Date: 9<sup>th</sup> December 2024  
Our Ref: 20050384  
Your Ref: EN010135  
Site address: Stonestreet Green Solar

**RE: Application Ref. EN010135 – Solar photovoltaic array plus energy storage with associated infrastructure and grid connection, with a generating capacity greater than 50MW.**

This letter is written in response to the Stone Street Green Solar Written Representations request which are due on the 9<sup>th</sup> of December 2024. Kent Wildlife Trust's Written Representations expand on the comments made during the Relevant Representations, which were submitted in September 2024. Kent Wildlife Trust's remit includes impacts to biodiversity within Kent. We have reviewed relevant documents submitted within the DCO against national and local legislation and policy. A summary of our main concerns is described in the box below, with more detailed comments in the main body of the letter.

drawing no. **5535-LLB-XX-XX-DR-Ec-0018**
drawing title **Environmental Statement Figure 9.3**
Locations of Ancient Woodland Sites

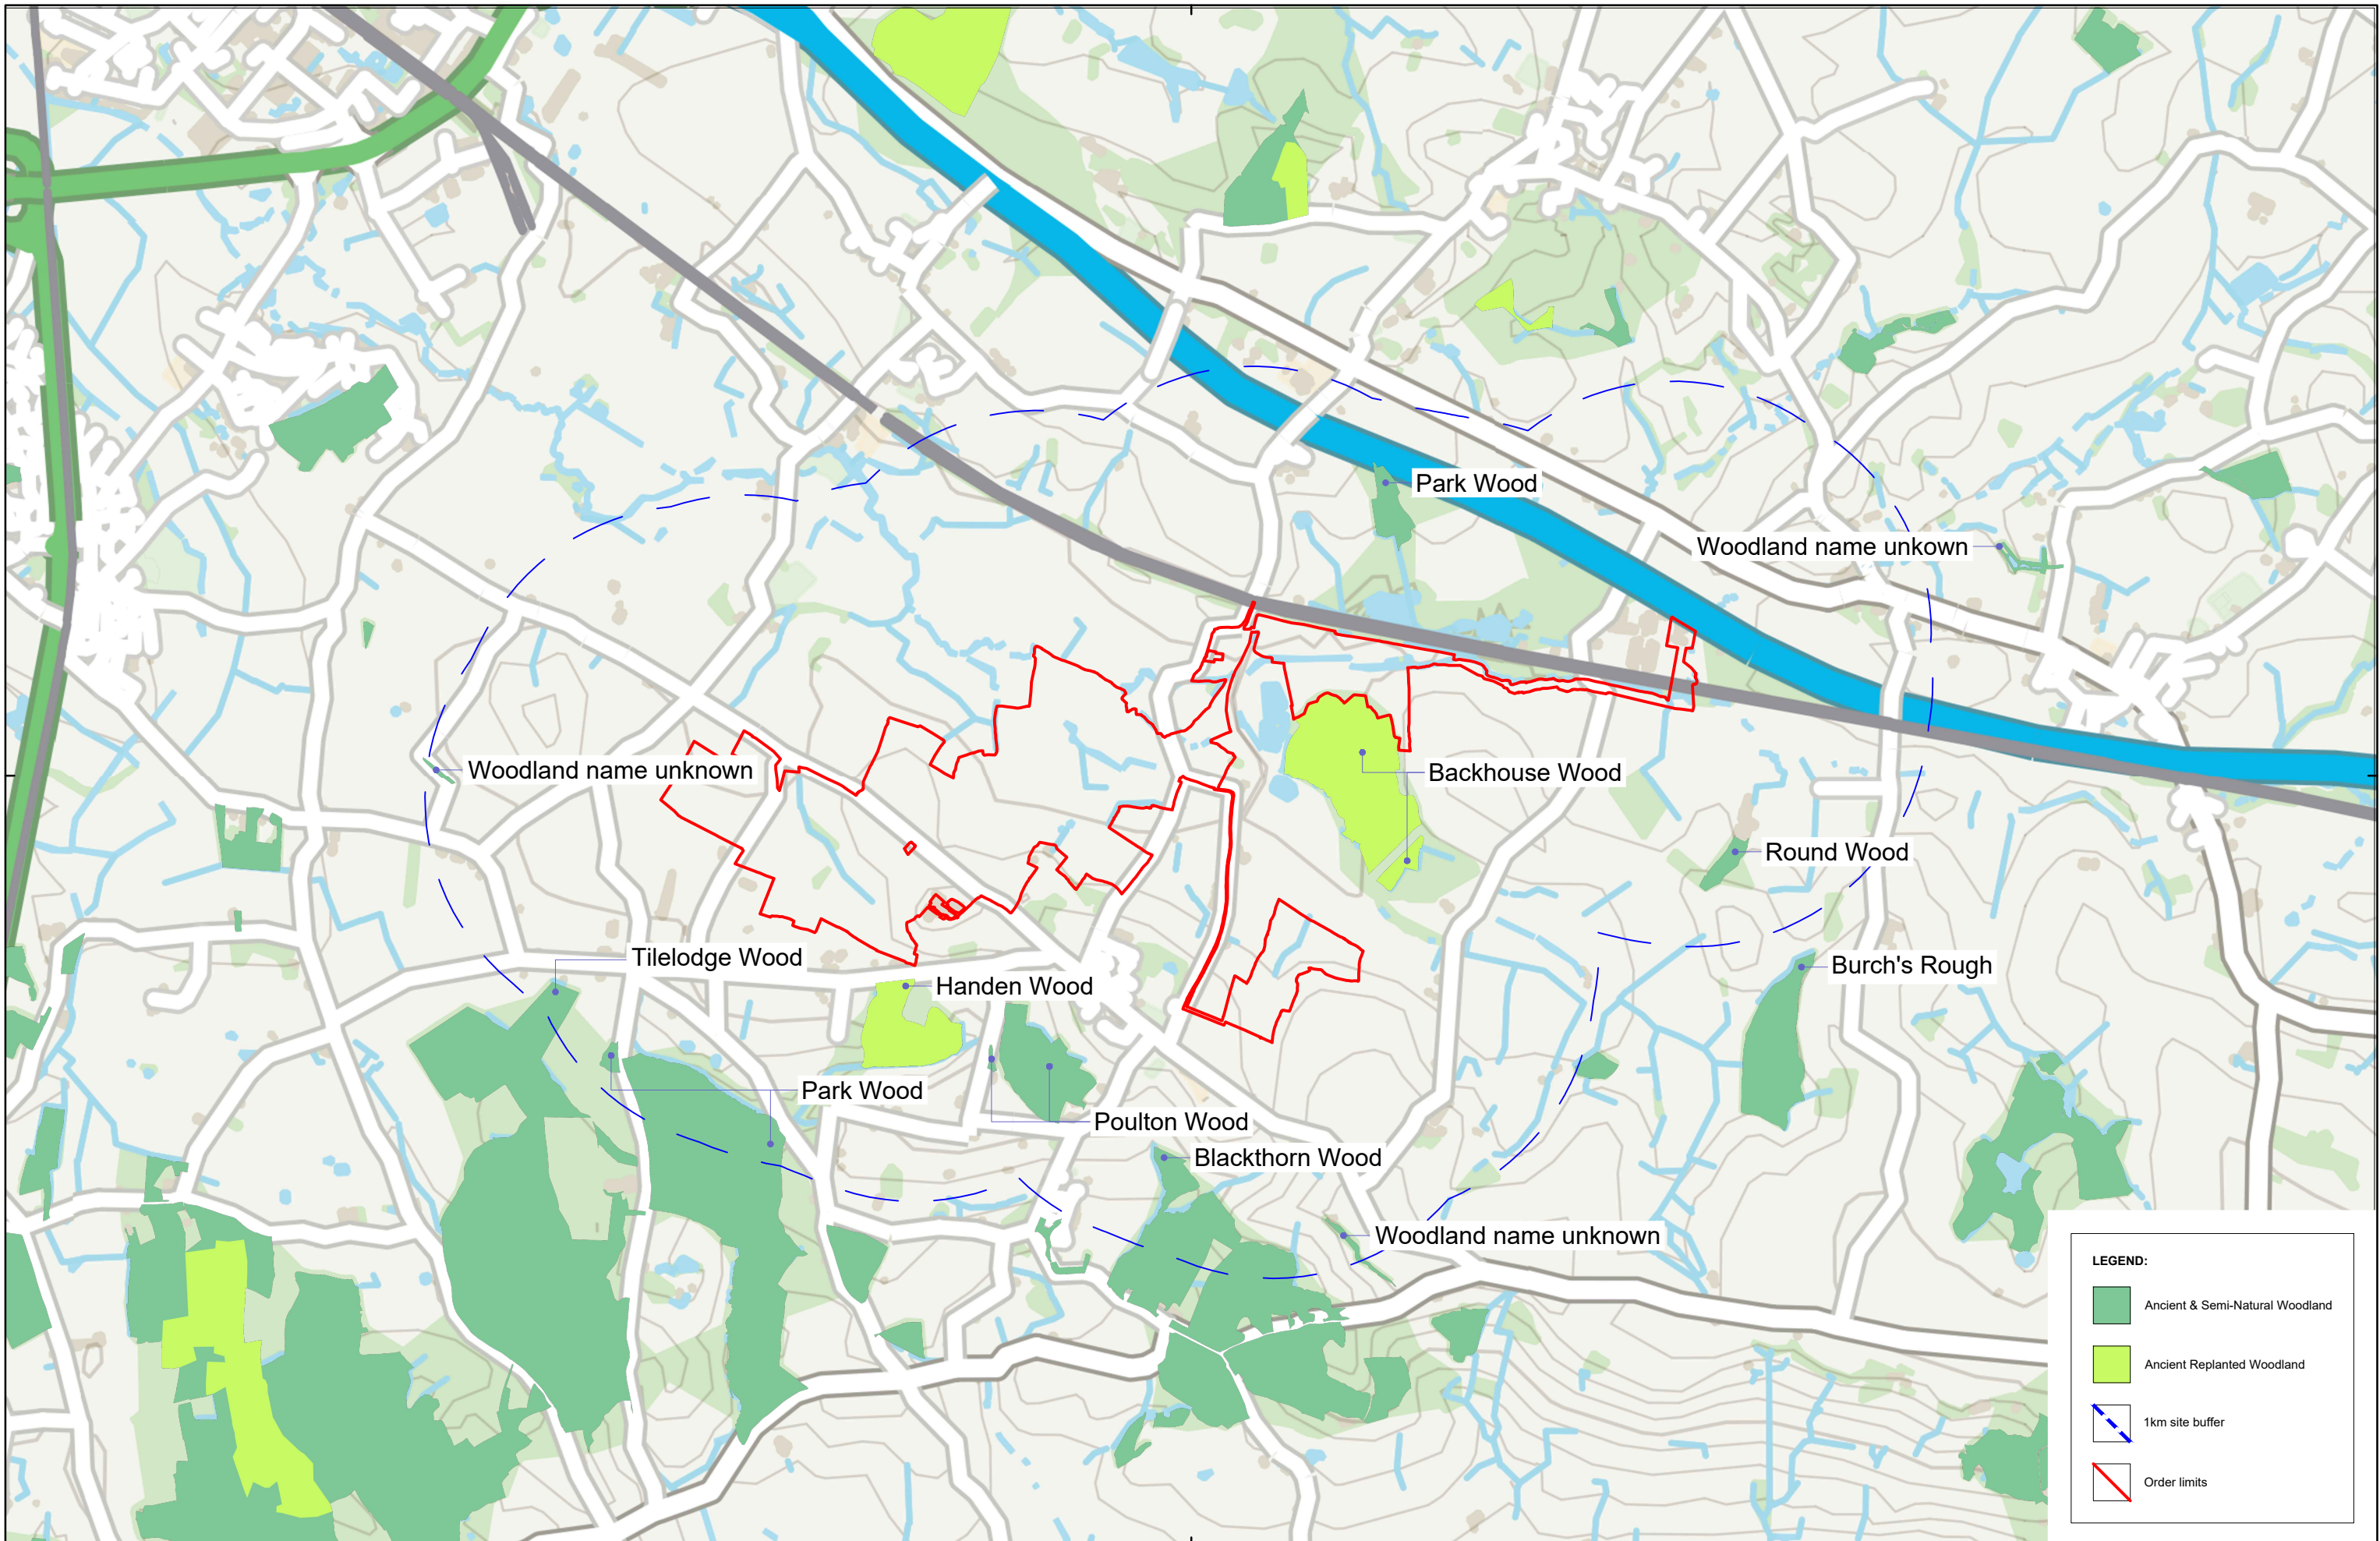
There is still a degree of uncertainty around the impacts of the development, in terms of noise, dust, and light pollution, on Backhouse Wood Local Wildlife Site (LWS) and its ancient woodland. Justification for the minimum buffer of 15 metres from the ancient woodland has not been provided and given the potential impacts from the proposal on this irreplaceable habitat it is strongly recommended that a larger graduated buffer is provided.
